West Sussex Local Access Forum

28 July 2017

Planning Application A/44/17/OUT at Land to West of Brook Lane and South of A259 Angmering BN16 3JL

MASTER PLAN

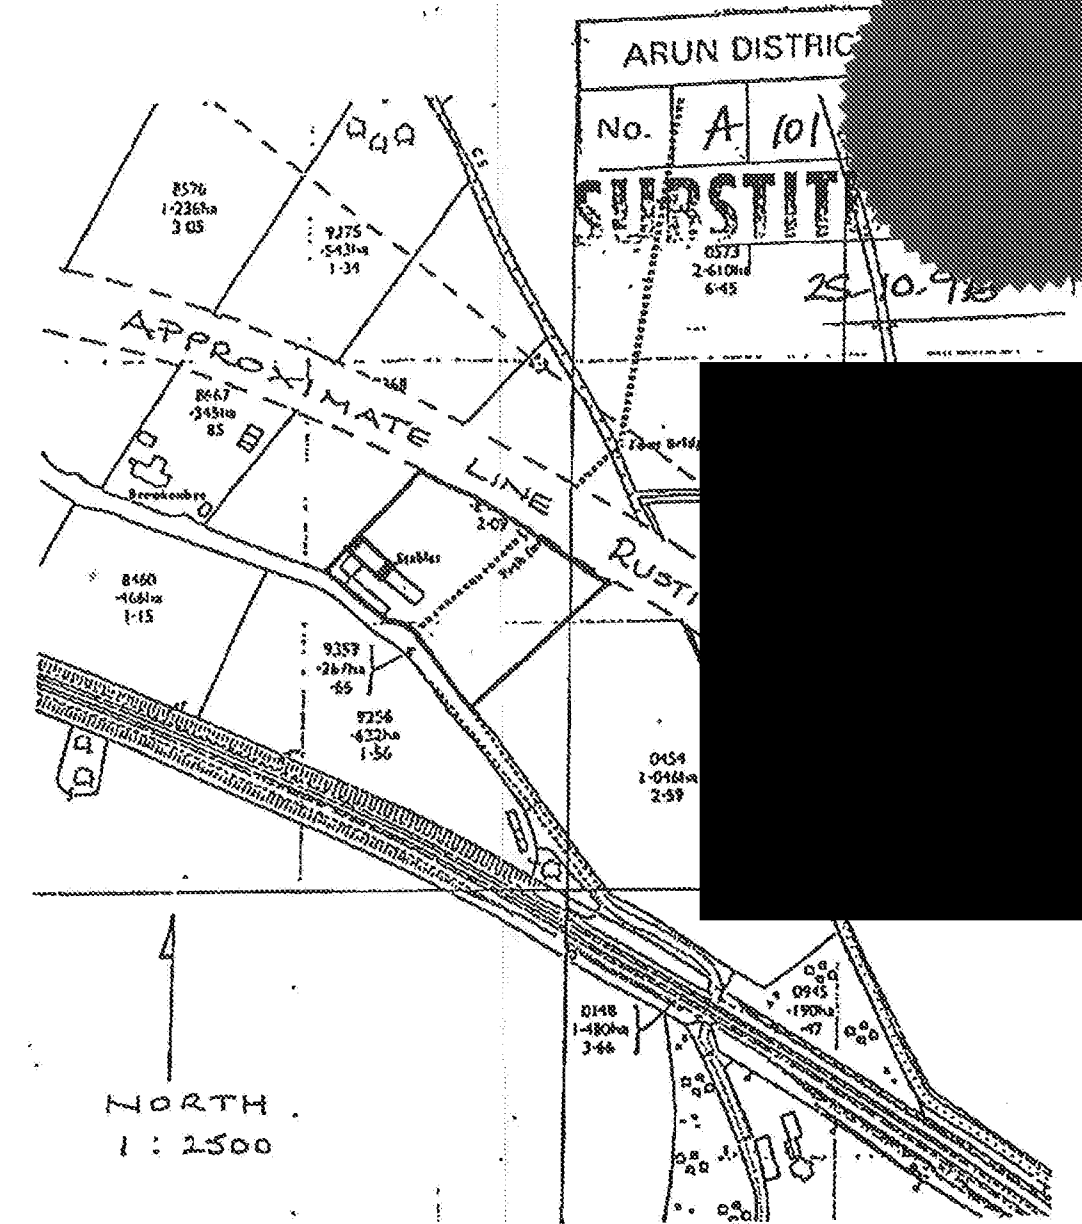
The application includes a proposal to replace an existing at-grade railway level crossing with a footbridge. The new bridge will serve the care home, residential and commercial properties proposed for the new site in addition to other premises proposed north of the railway line and the many existing mixed property types south of the railway line. In providing for walkers it was noted that cyclists would be accommodated by provision of a channel up each stair flight.

Members raised concerns about any proposal for a stepped bridge as they consider that any new crossing should benefit as many potential users as possible, including those with pushchairs or with impaired mobility. The Forum therefore requests that the design of the new footbridge incorporates ramped approaches (to comply with the Equalities Act) and is of adequate width to provide safe and easy access for all users. Members also note that existing PROW cross the site both north-south and east-west.

Improvements to these paths would maximise the benefit of the crossing and would improve access.
